Design Studies
SDRP Design Response

PLC Greyhouse Precinct
12 October 2021 R.4

PROJECT: Pymble Ladies College
RE: State Design Review Panel (SDRP) – Review 1, 18 August 2021

NORTH / SOUTH ELEVATION

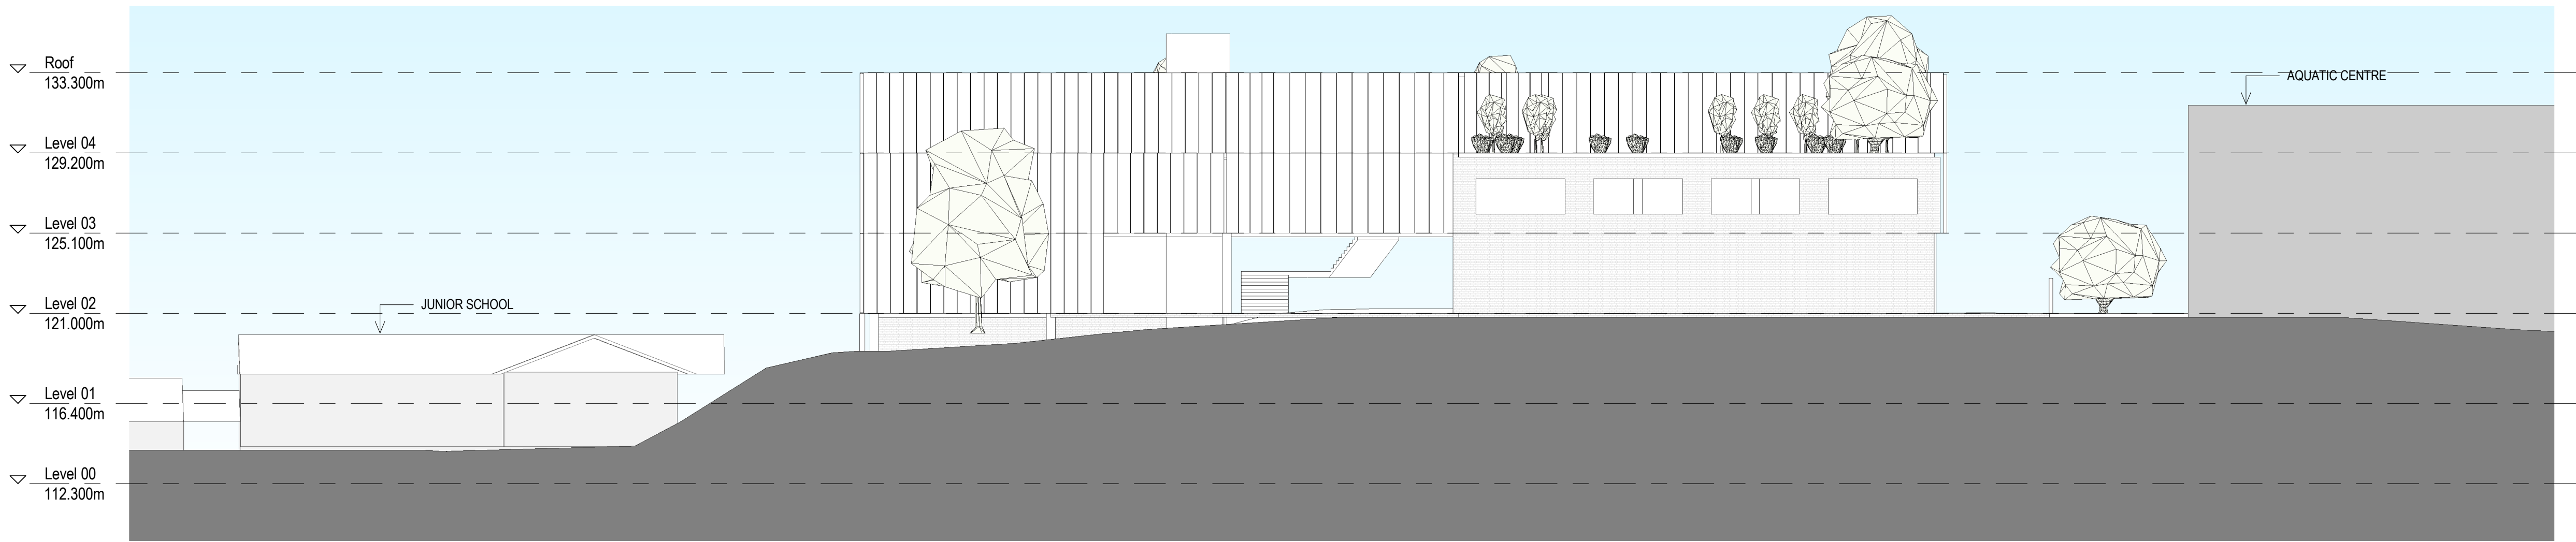
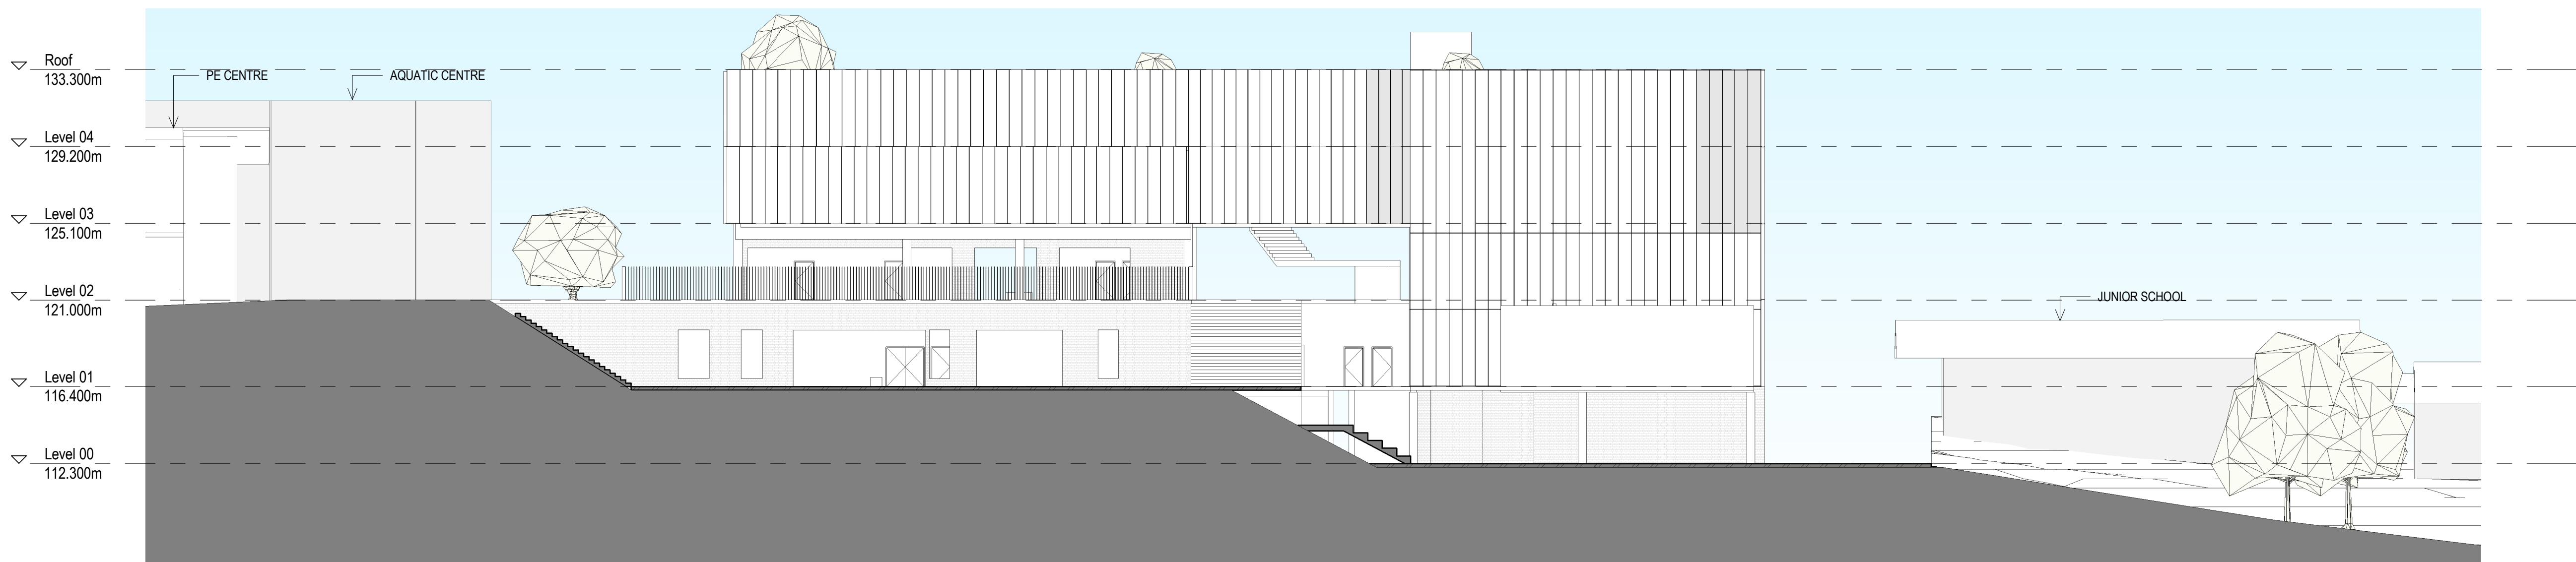
11. The new building has a clear formal relationship with the interior character of the site and its historic buildings. Presently this same language is carried over to the suburban side of the building that faces Pymble Ave. In relation to the previous two points, re-examine the scale, character, and architectural language of this elevation so that it might fit into its context more appropriately.

The architectural expression of the suburban elevation has been broken down and articulated through the use of four key material and compositional elements:

- Brick base - podium brick material is experienced from south elevation predominantly (the motif of where the building touches the ground) to reduce the scale of the continuous tallest portion of the building

SHADOW DIAGRAMS -
SHEET 1

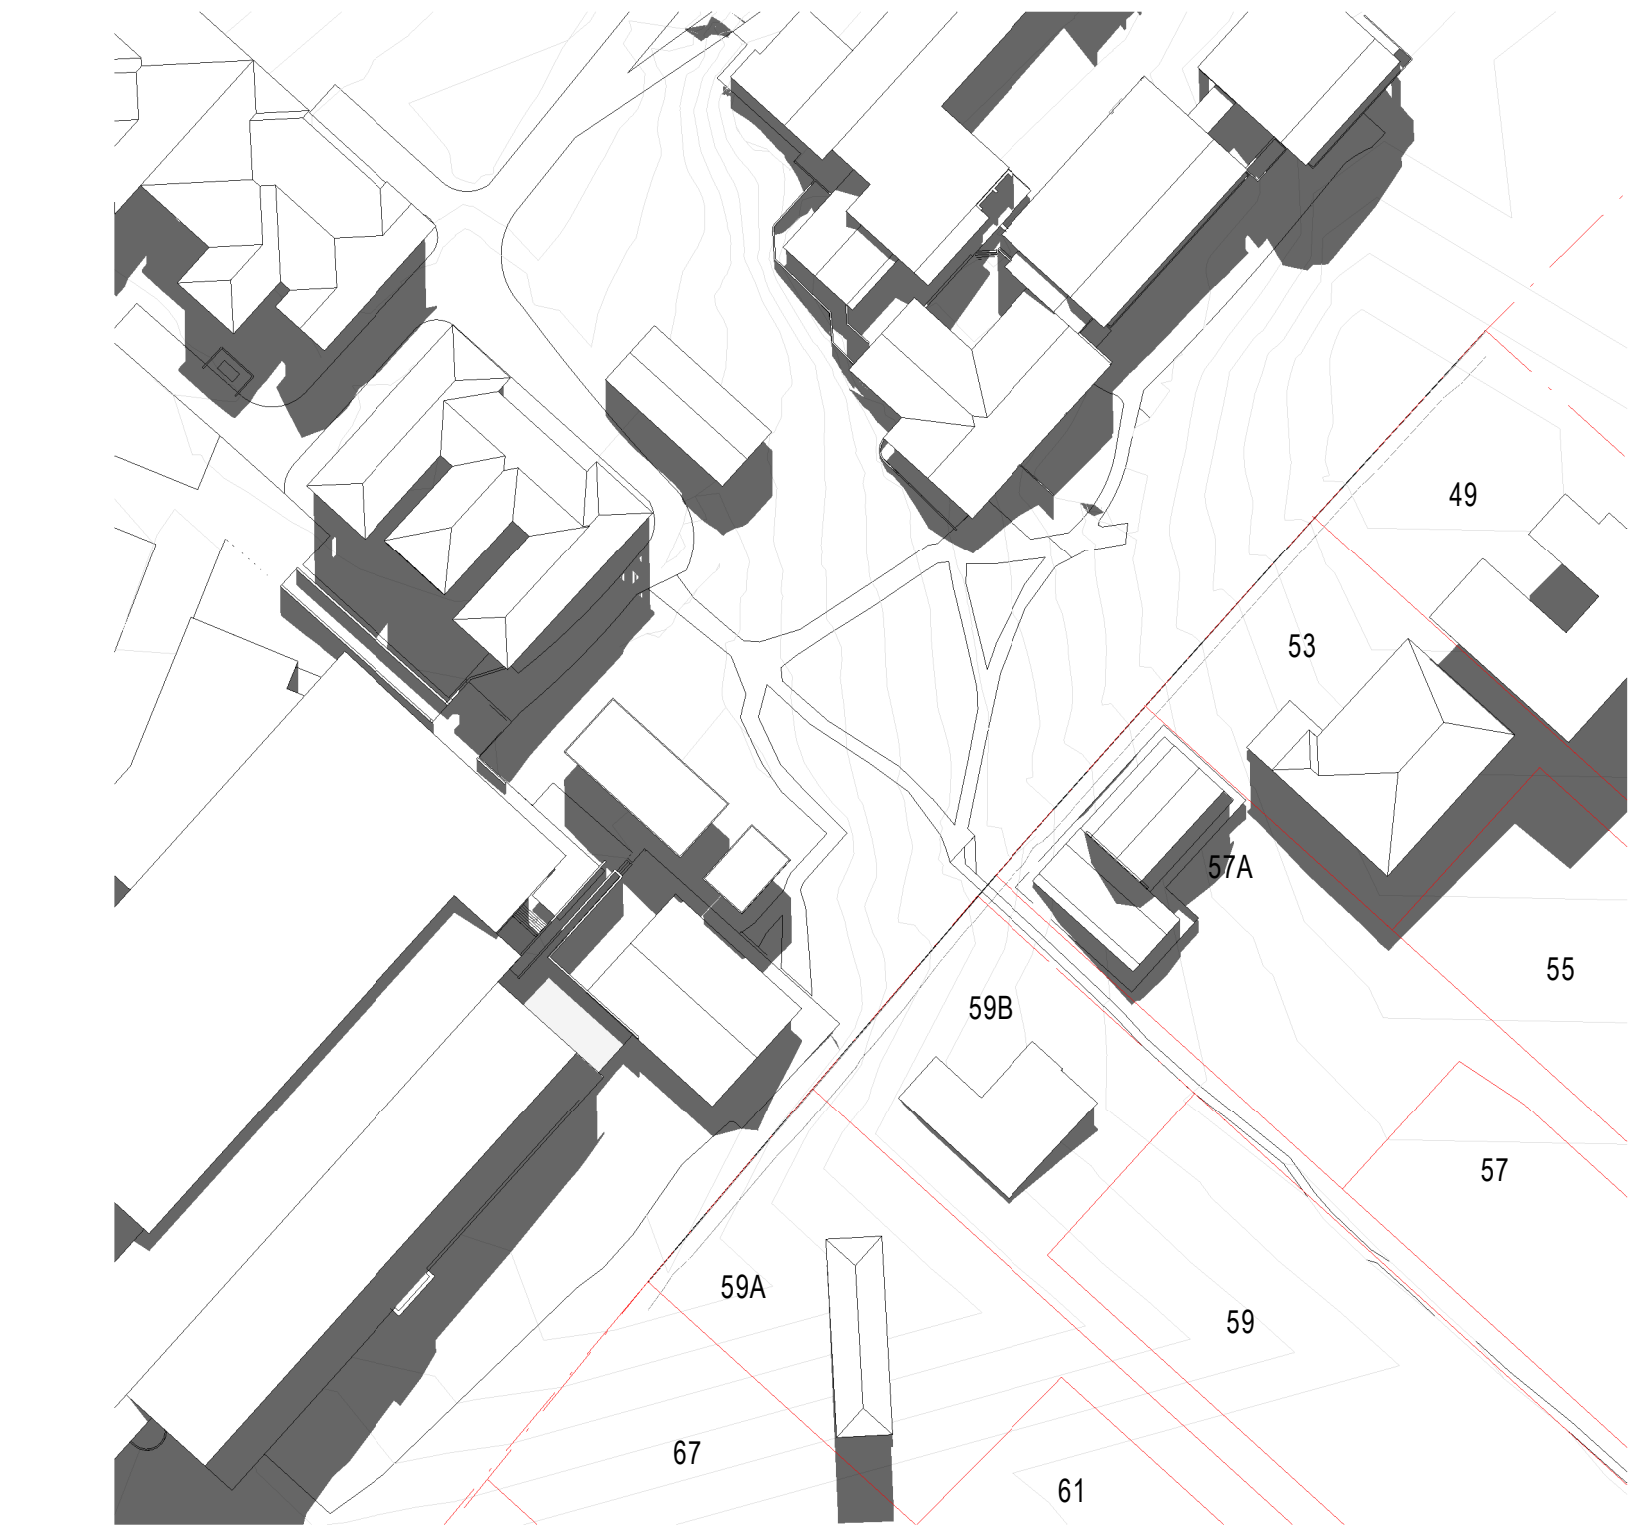
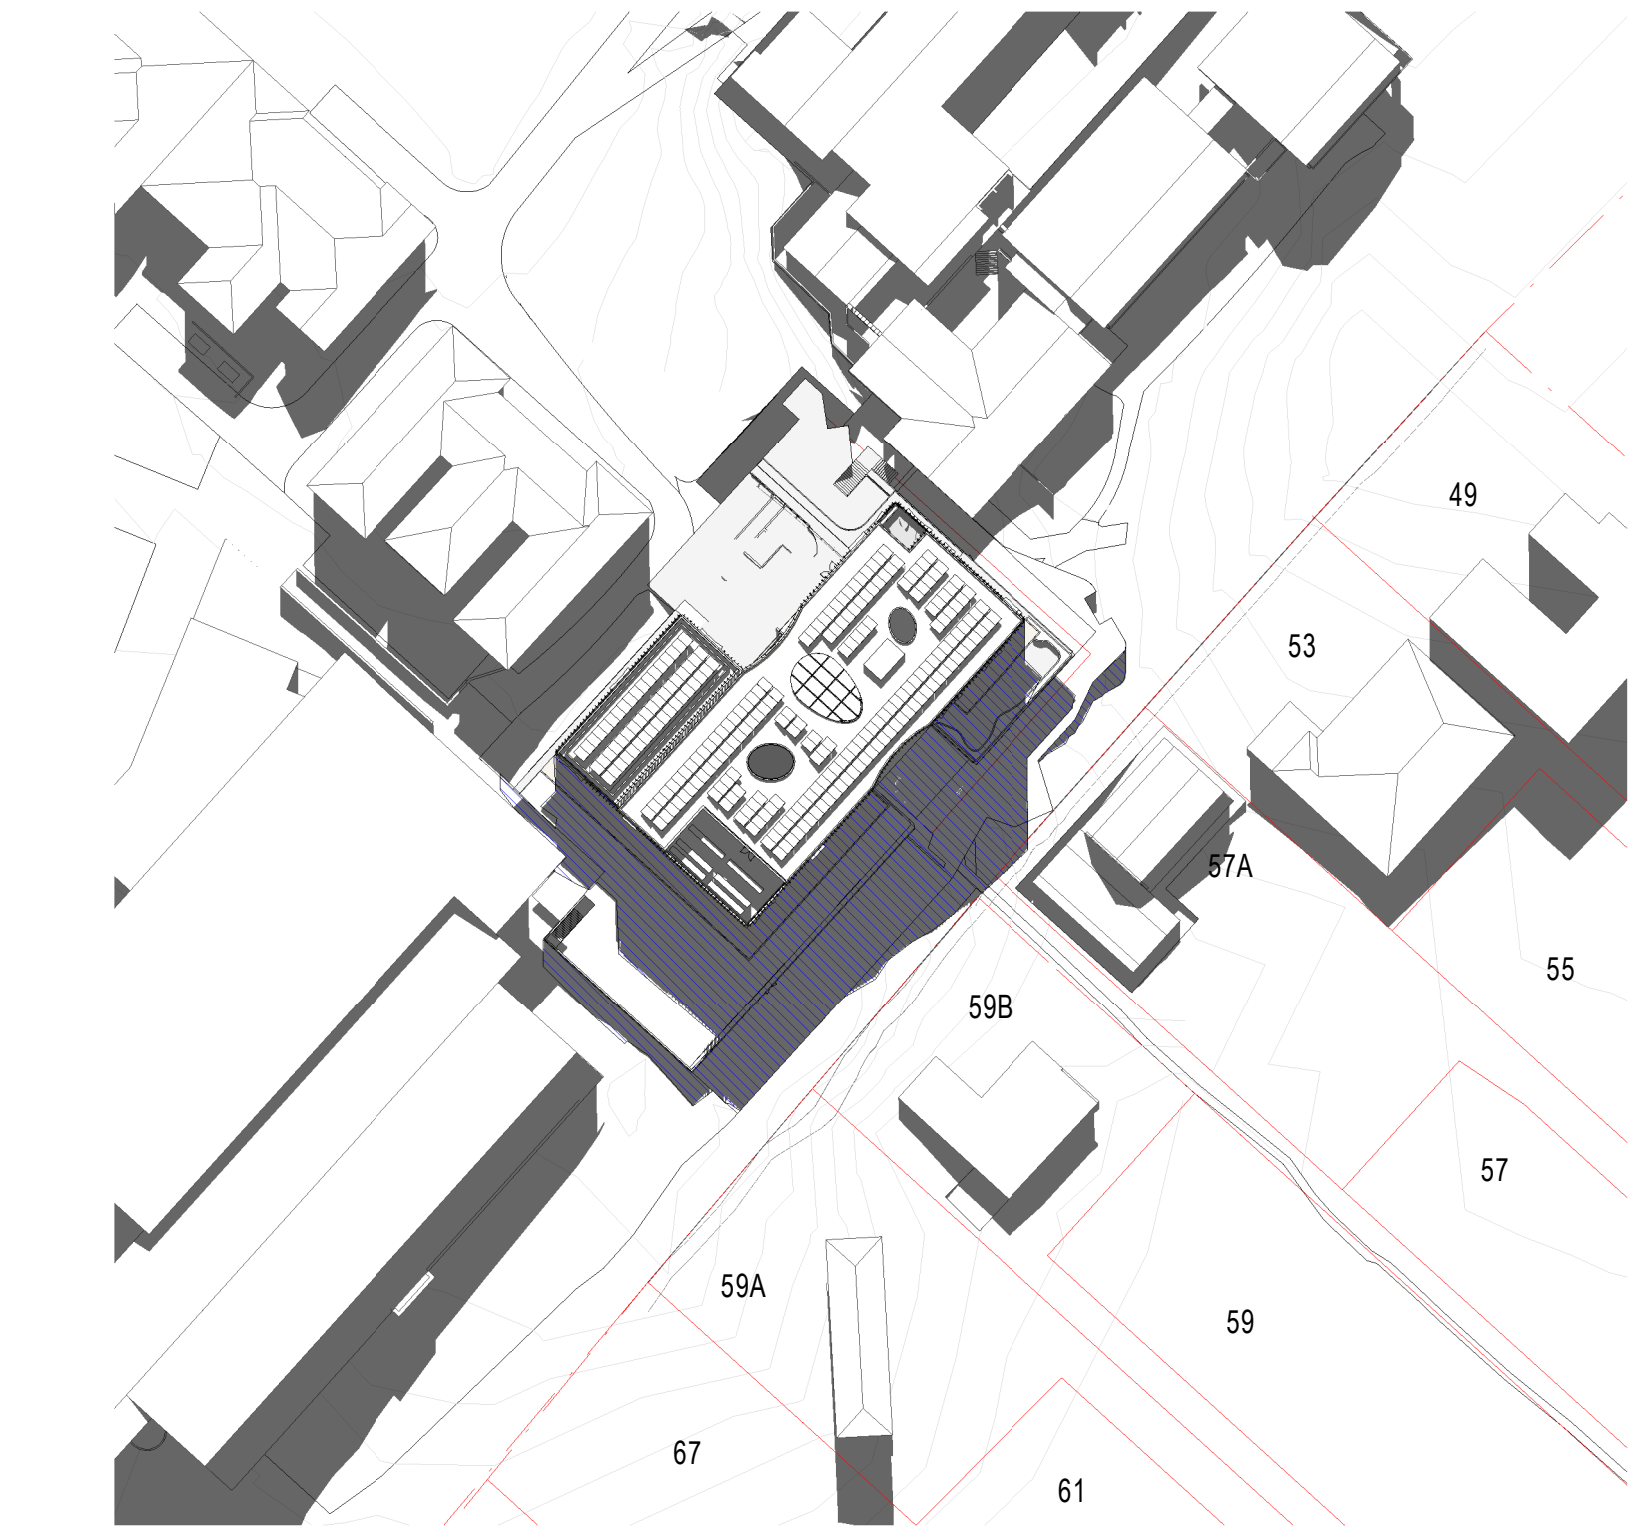
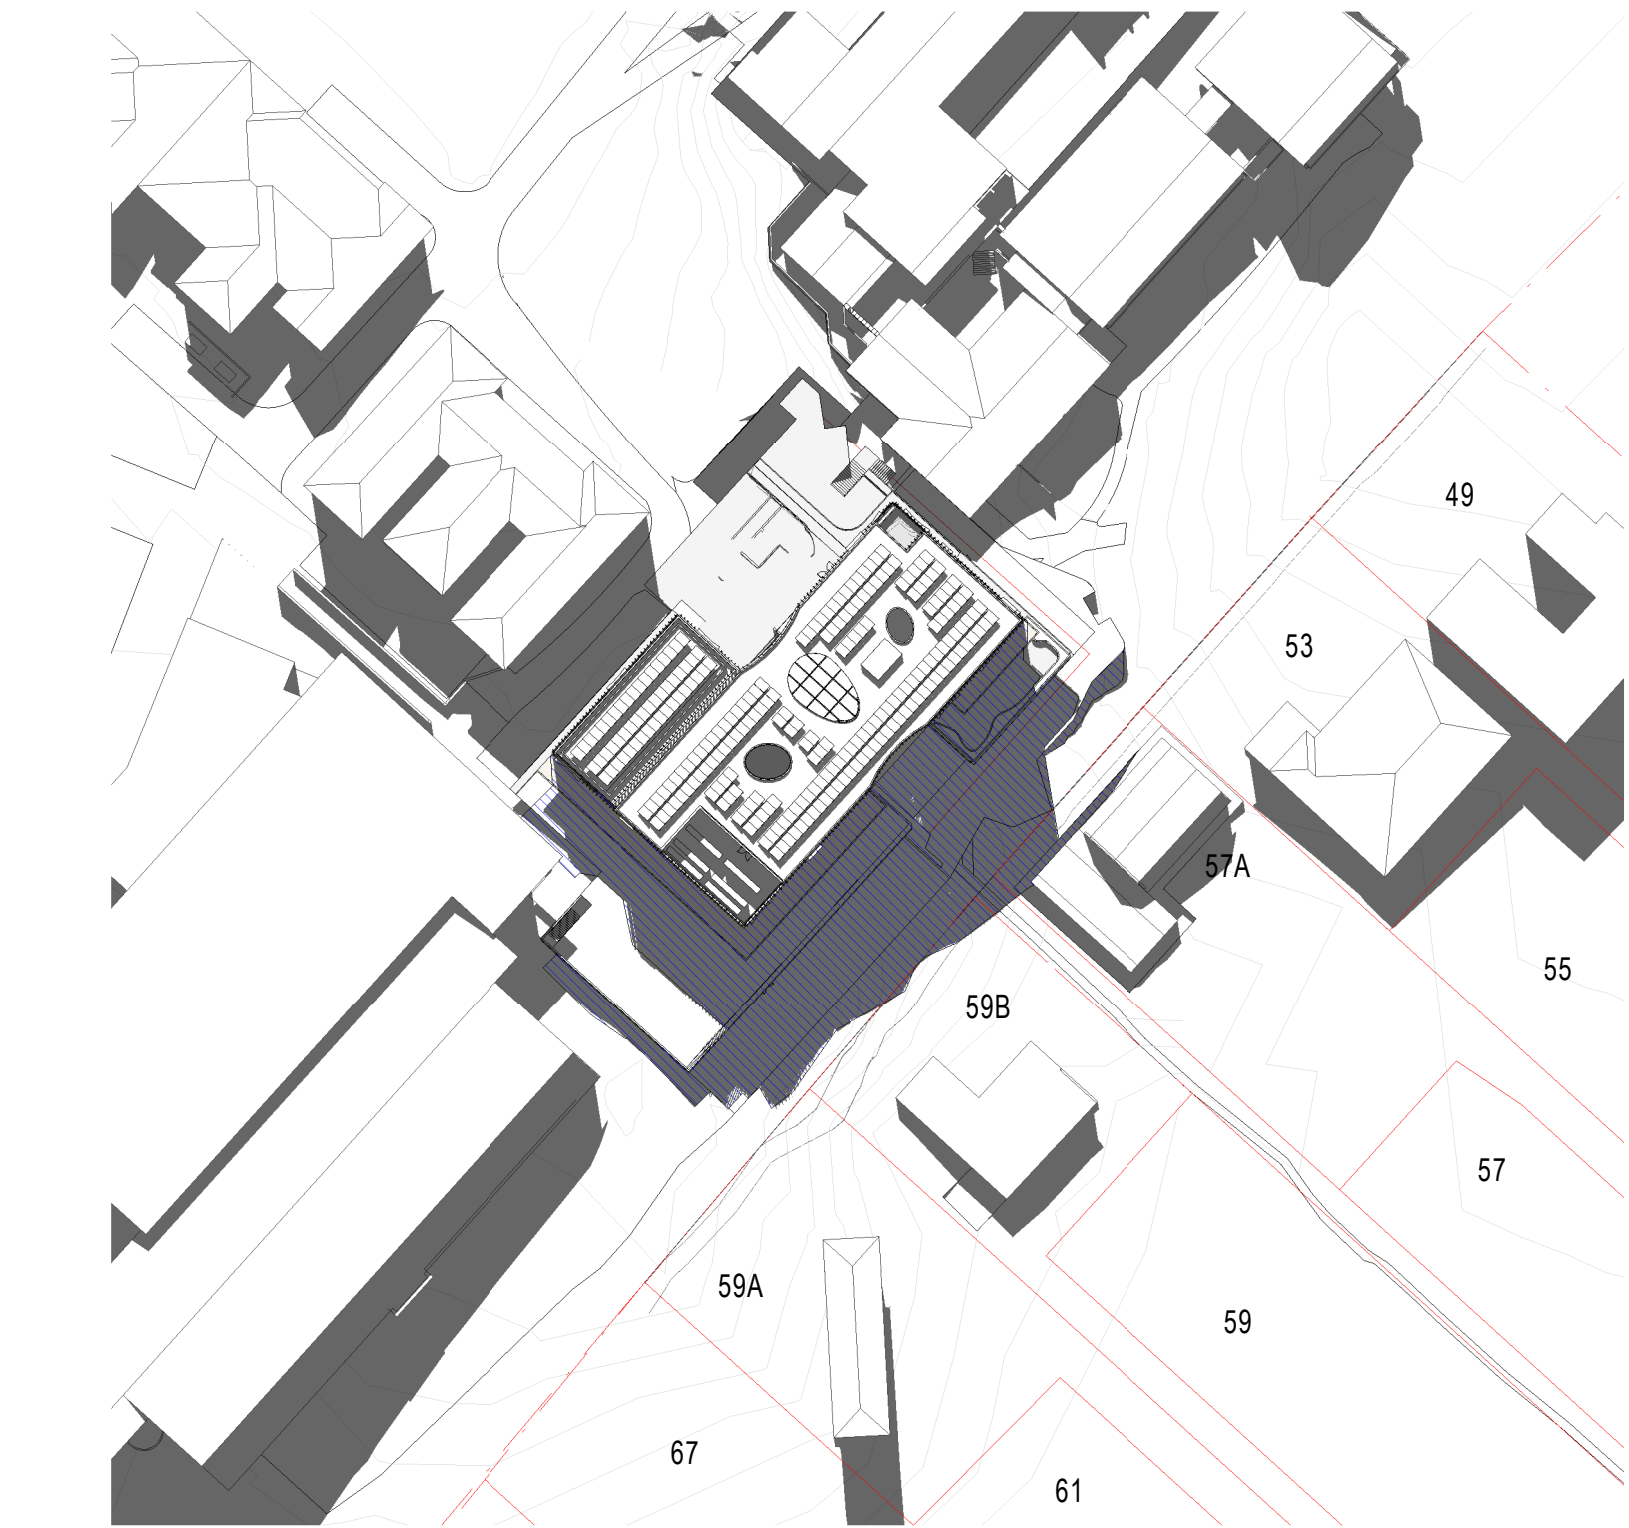
9. Review if the overshadowing of neighbours on Pymble Ave can be minimised through changes to the corners and edge of the building. Review the northern end of the new building and consider reducing the bulk and form to increase sunlight.
10. Re-examine the translation of the built form from sketch design to final design. Consider whether the architectural elegance has been lost in the formalisation and increase in scale of the building.

Shadow encroachment – from 11.59am (+4 min)

Shadow encroachment – from 12.04pm (+9 min)

Shadow encroachment – from 12.15pm (+20 min)
